Subject: Meadow Lake Industrial Park (I-2) Rezone (I-221)

The Community Services Department has reviewed the Meadow Lake Industrial Park (I-2) Rezone application and is providing the following administrative comments on behalf of El Paso County Parks.

**Development
Application
Permit
Review**

I-2 REZONE LEGAL DESCRIPTION

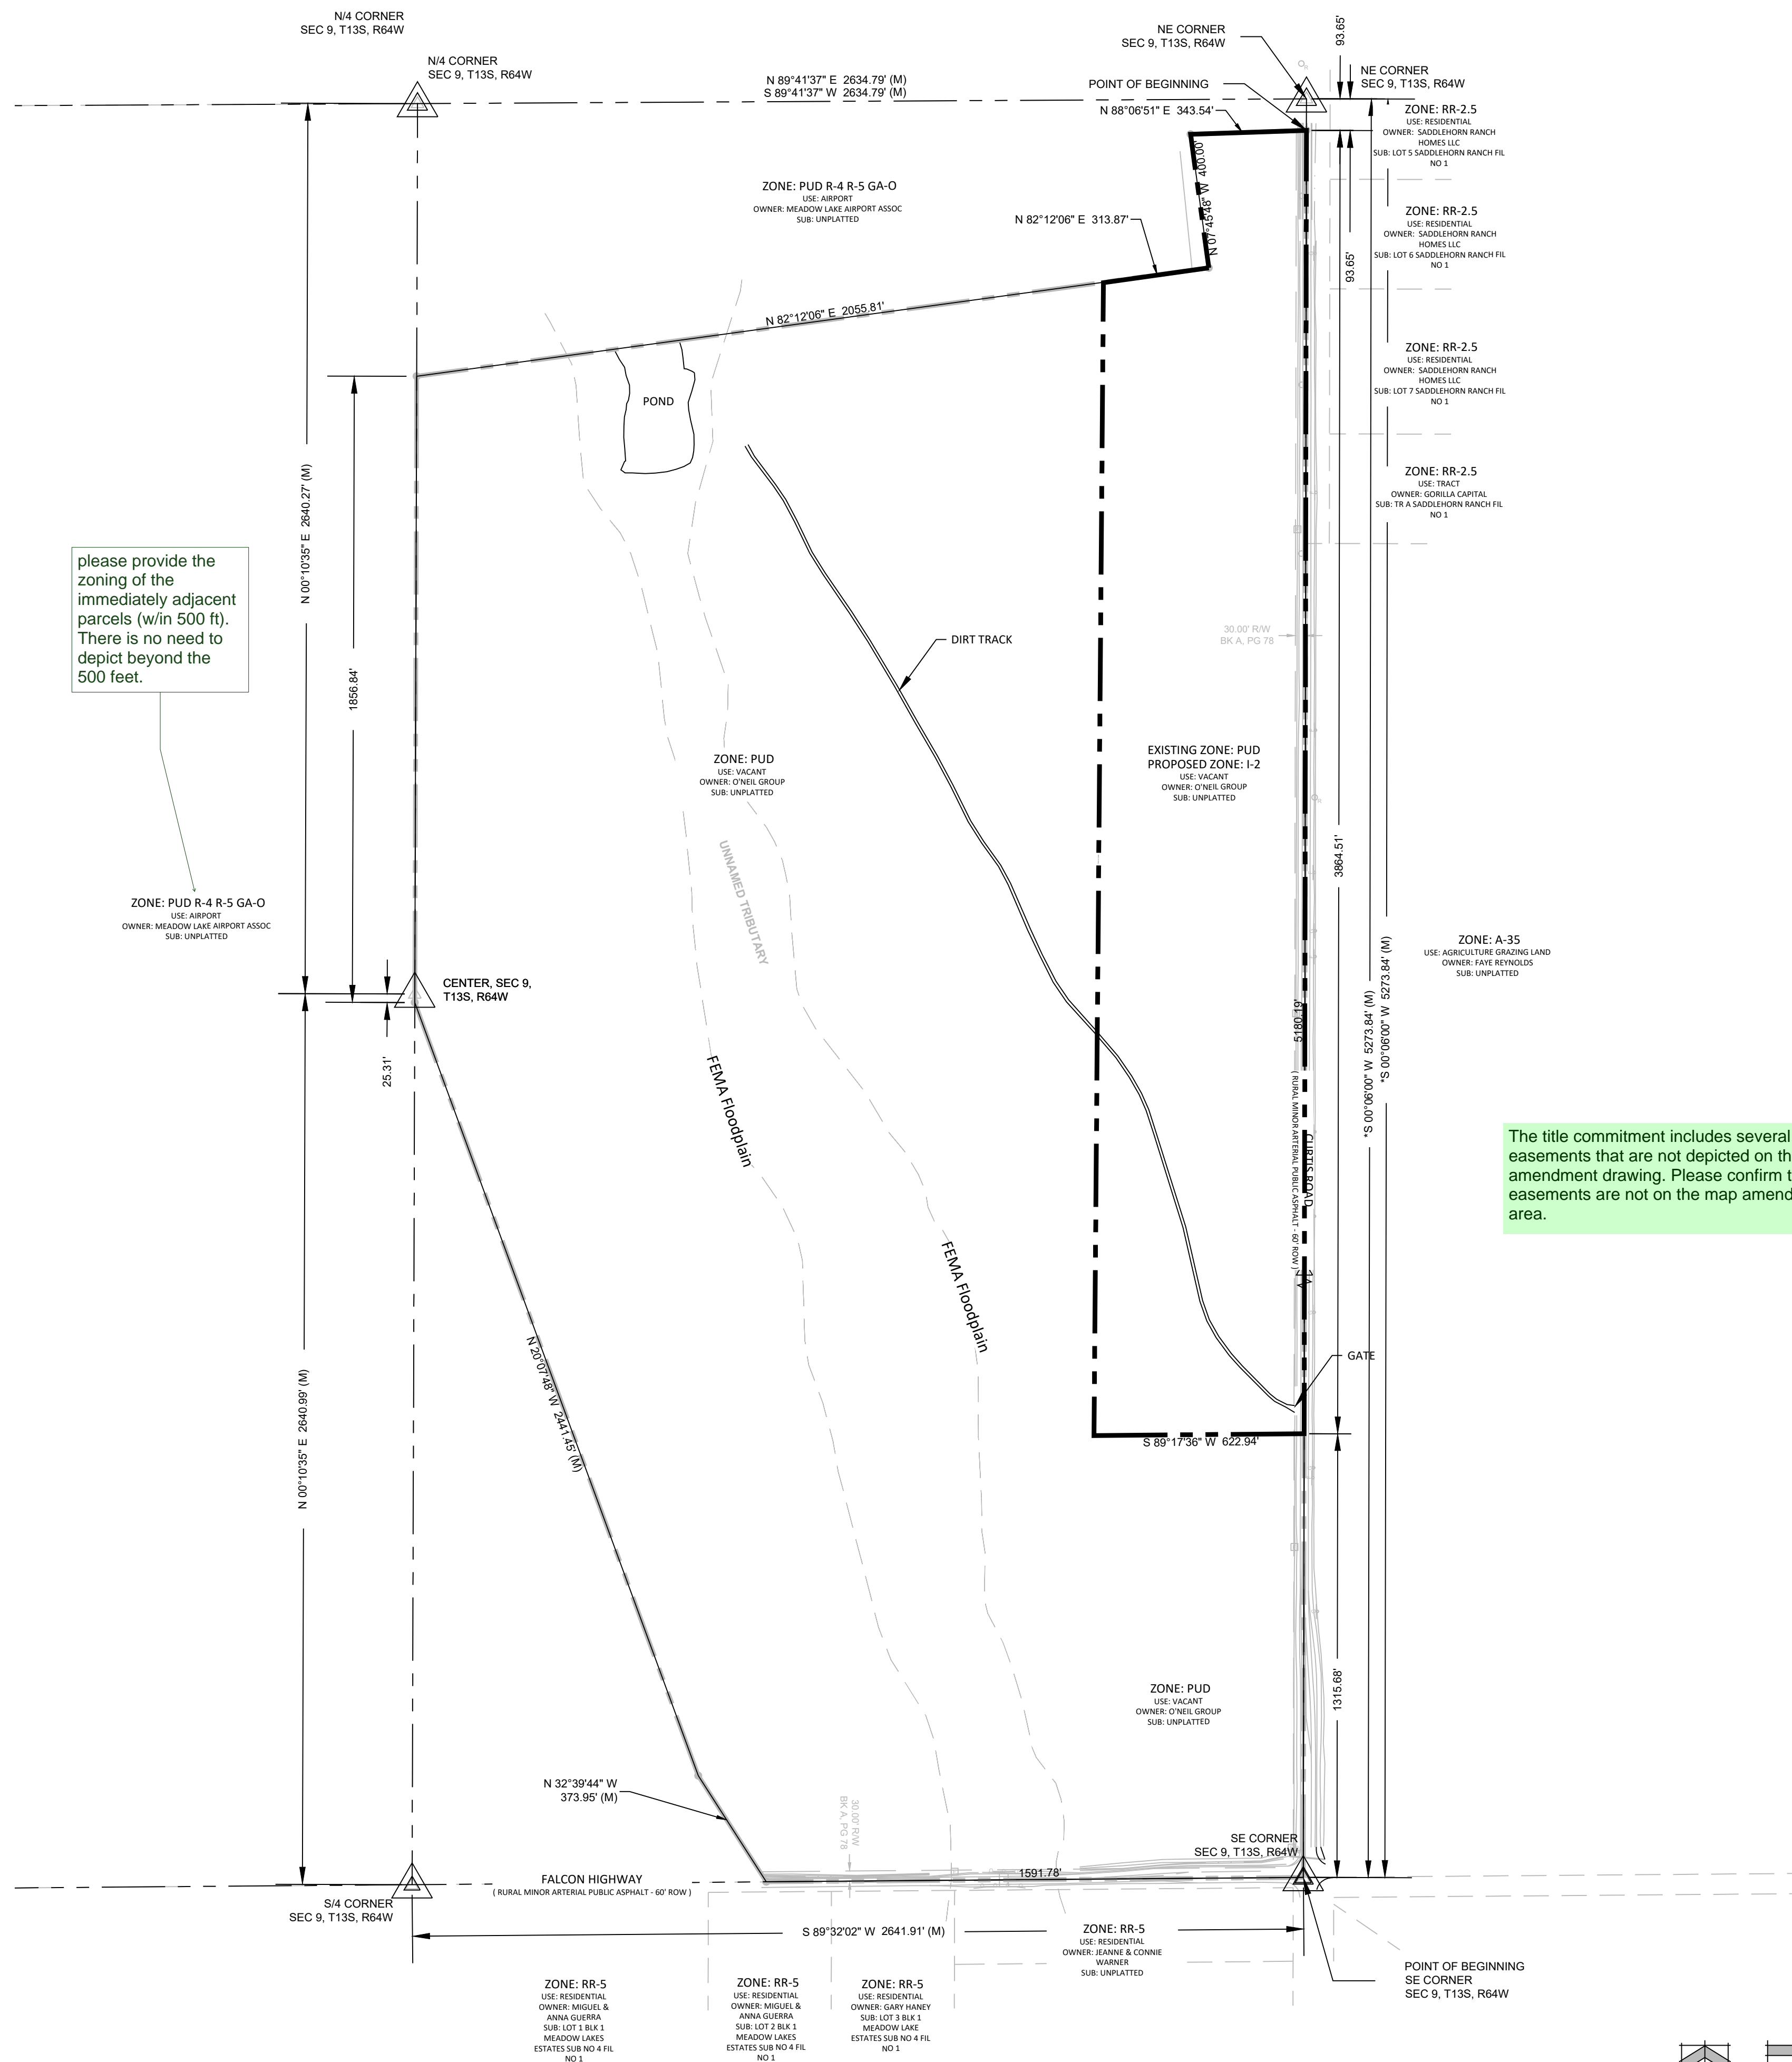
County Parks requests trail easements where development projects impact proposed County trails. As it pertains to this application, the County requests that the landowner provide a 25-foot public trail easement along the west side of Curtis Road that allows for the construction and maintenance by El Paso County of a secondary regional trail, and this easement shall be shown and dedicated to El Paso County on the Final Plat.

Recommend that the Planning Commission and the Board of County Commissioners include the following conditions when considering and/or approving the Meadow Lake Commercial Park Rezone: (1) No regional park fees are recommended, as the Board of County Commissioners has elected to not require park fees for commercial subdivisions (2) Dedicate and provide to El Paso County a 25-foot public trail easement along the west side of Curtis Road that allows for the construction and maintenance by El Paso County of the Judge Orr Secondary Regional Trail, and this easement shall be shown and dedicated to El Paso County on the future Final Plat.
